Recommendation Report for Planning Permission for Works or Extension to a Dwelling

REF NO: EP/128/18/HH

LOCATION: 39 Hillview Crescent
East Preston
BN16 1RG

PROPOSAL: Loft conversion & single storey rear extension (re-submission of EP/89/18/HH).

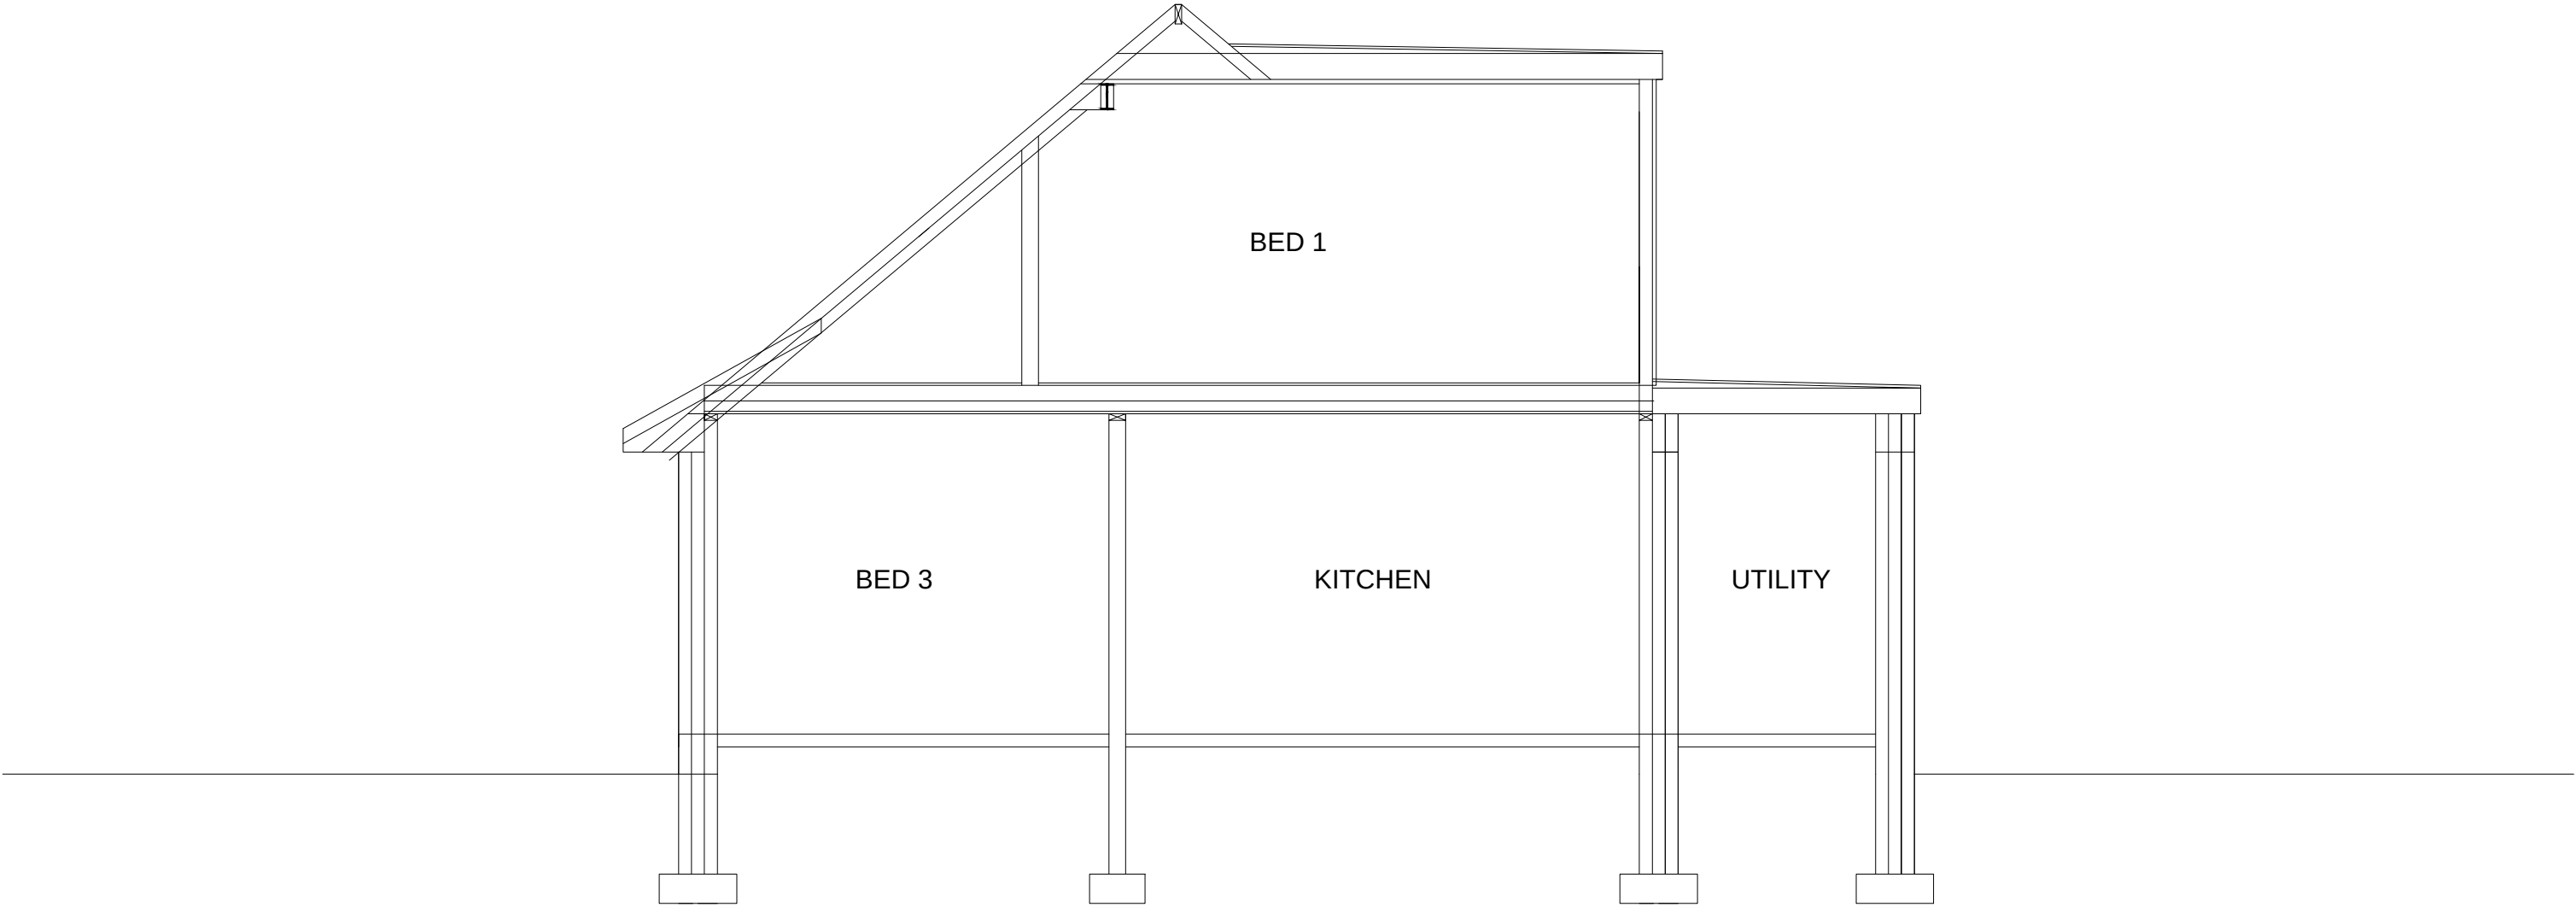
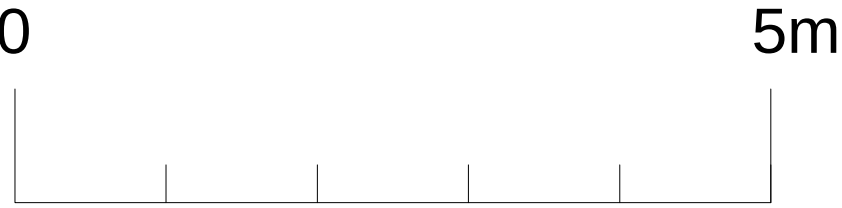
Due to its prominent nature and location the proposed roof alterations will alter the existing appearance of the dwelling. The roof extensions are significant and result in altering the appearance of the existing bungalow and as such it is considered to conflict with policy D DM4 (a) of the Arun Local Plan. The proposed development also conflicts with Policy 3(ii) of the East Preston Neighbourhood Development Plan, in that the roof shape of the host dwelling is altered in order to allow for accommodation in the roof.

Approximately 30m to the North, the property opposite the host dwelling, 28 Hillview Crescent has a very similar roof shape. There are examples of similar roof alterations along the same road at 5, 11a, 33, 28, 44 and 46 Hillview Crescent. With regard to the design of the roof alteration itself, this has improved from that previously refused as it is less bulky and box like than the previous full gable ended proposal.

DRW NO 2b SCALE 1/50 (A3)
PROPOSED GROUND FLOOR PLAN

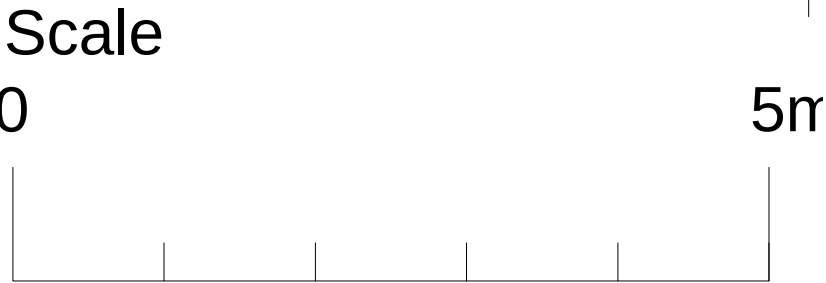
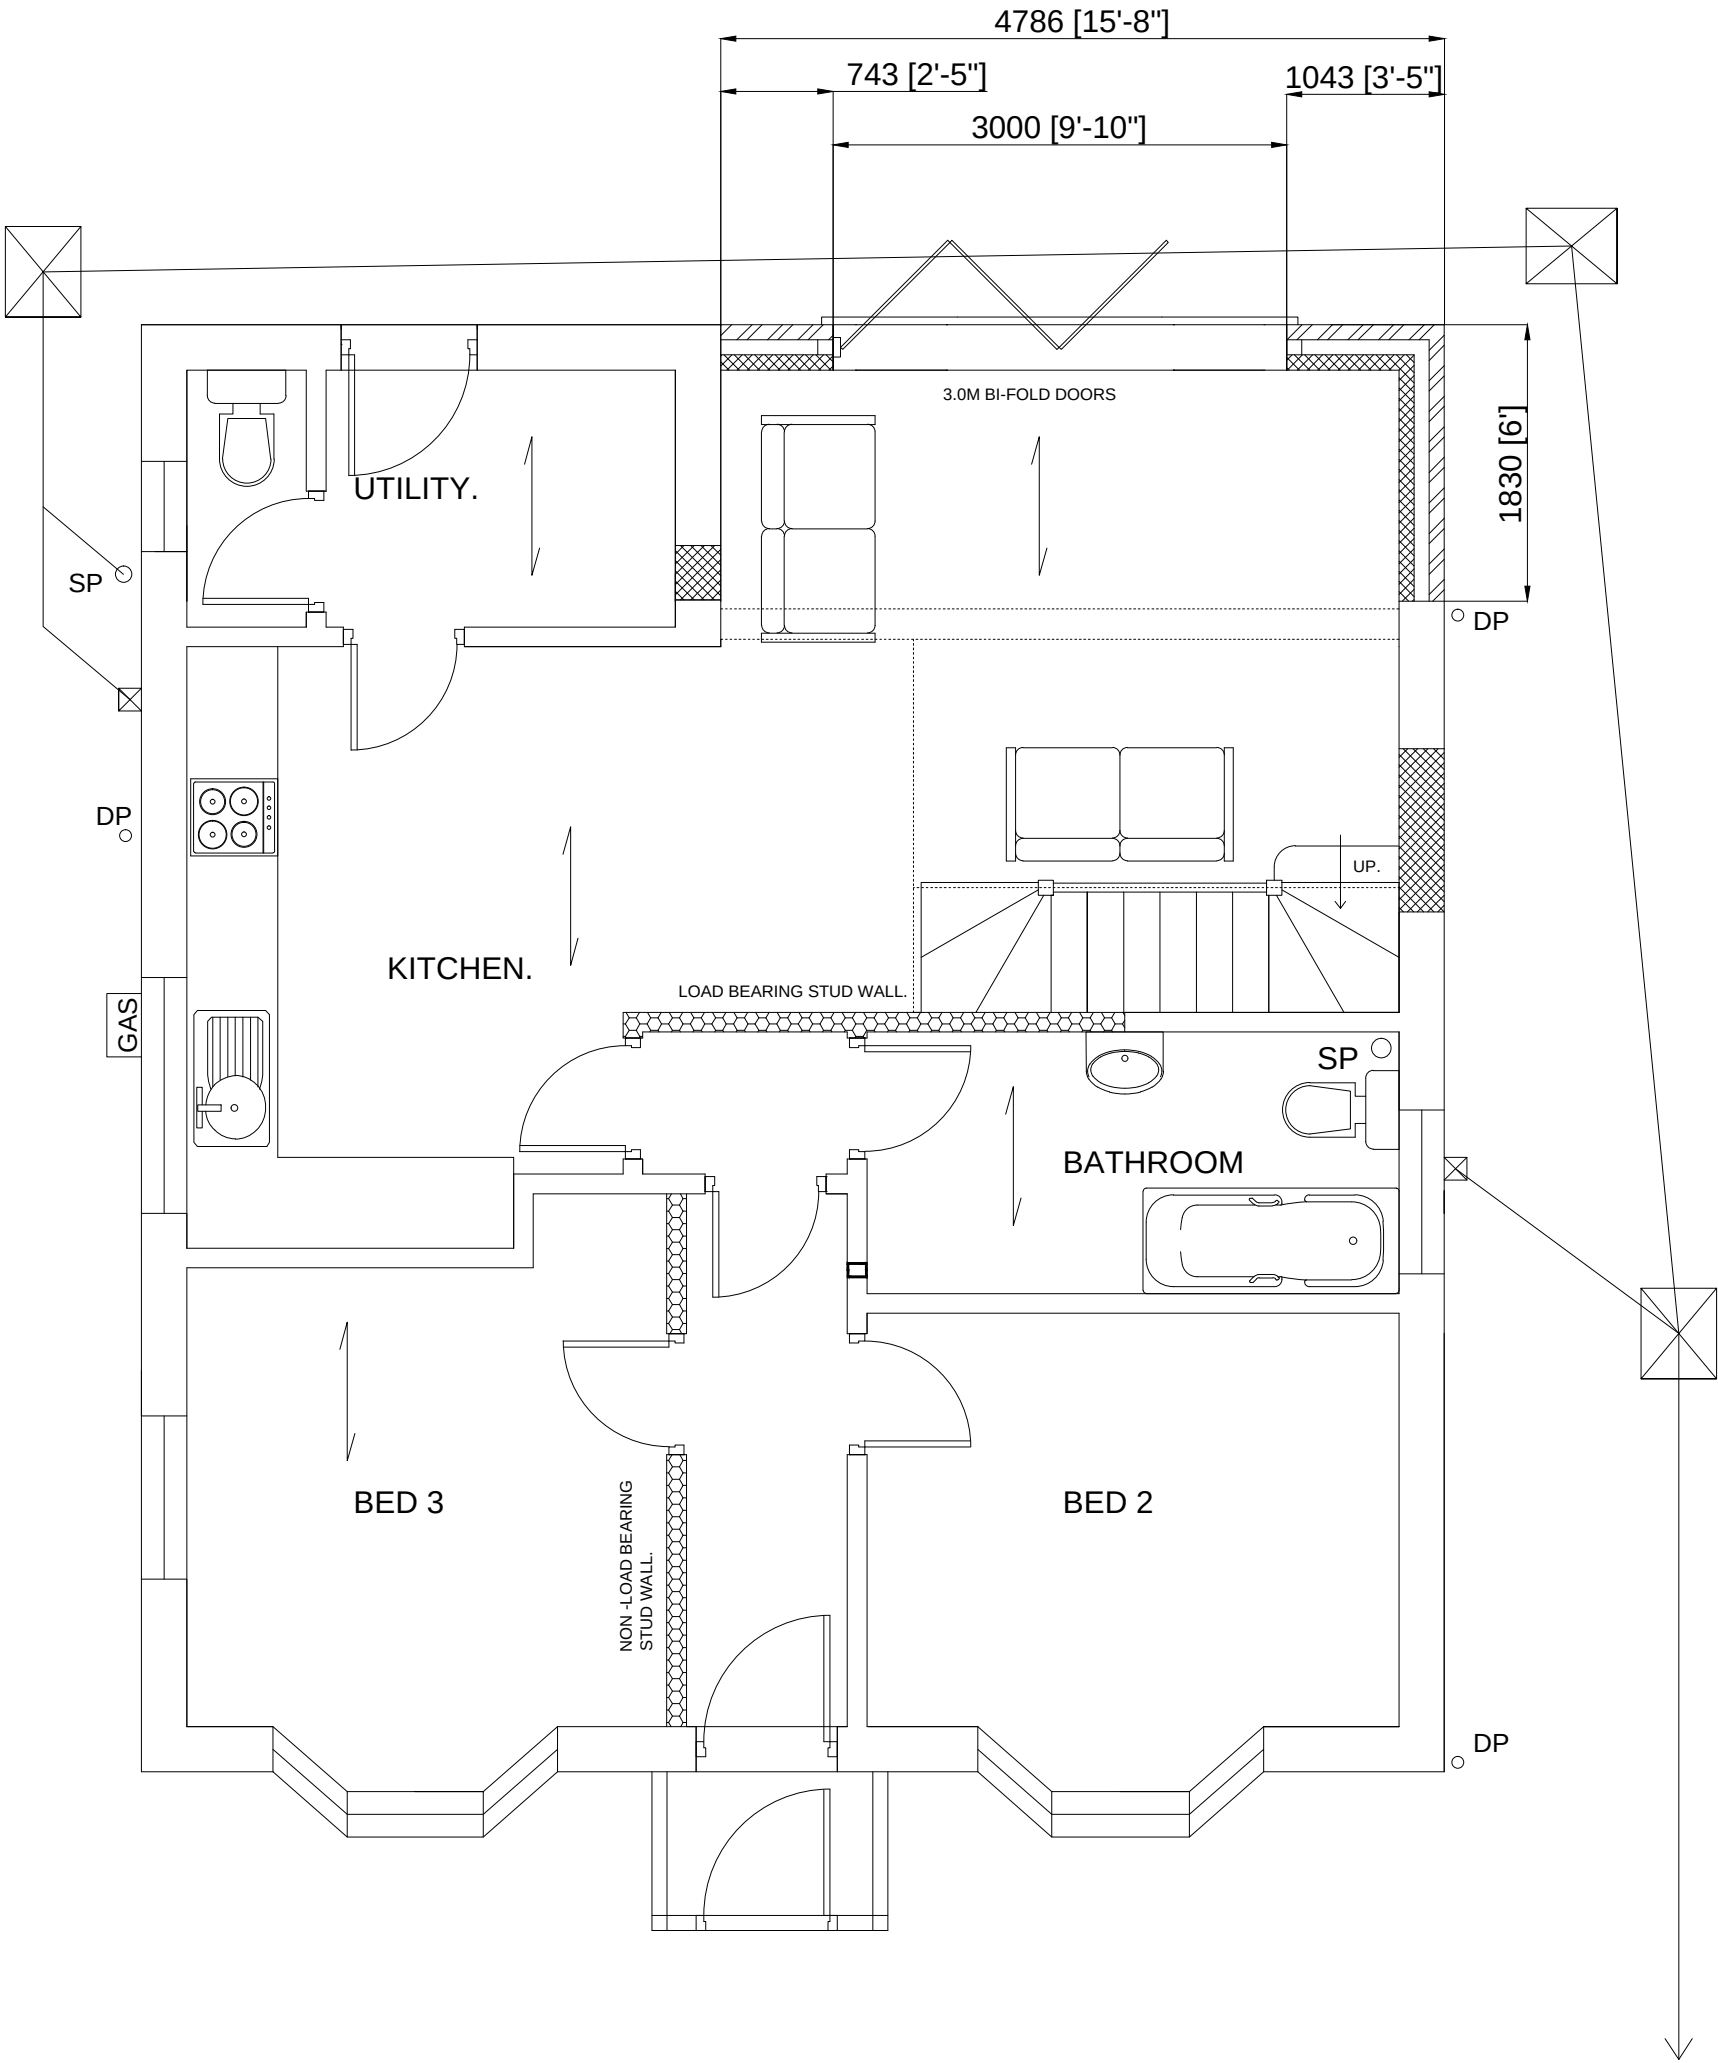
The proposed rear extension is considered to be an acceptable addition to the host dwelling, as it projects only 1.8m from the rear wall, bringing it in line with the existing rear extension. This is considered to appear well integrated with the host dwelling, as it 'squares off' the dwelling, creating a more visually unified dwelling.
